Our Ref: M/134/17/CLP
Your Ref:

Application for Lawful Development Certificate for a Proposed Use or Development

Development Lawful development certificate for the proposed temporary siting of 1 No. caravan.
Location Little Thatch 93 Middleton Road Middleton on Sea

BLOCK AND
SITE PLAN

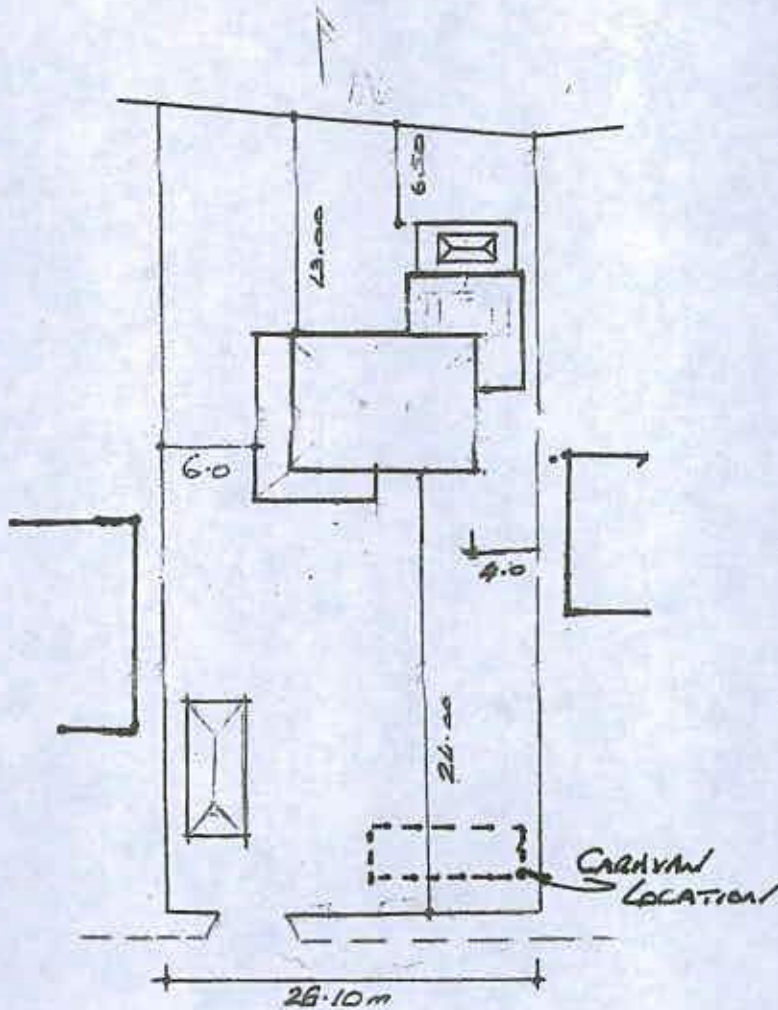
Block Plan Amend

Please submit 1 electronic or 3 paper copies of a block/site plan at a scale of 1:500 or 1:200. Further details of what must be included on the plan can be found in the National Validation Requirements. Please show the position of the proposed caravan.
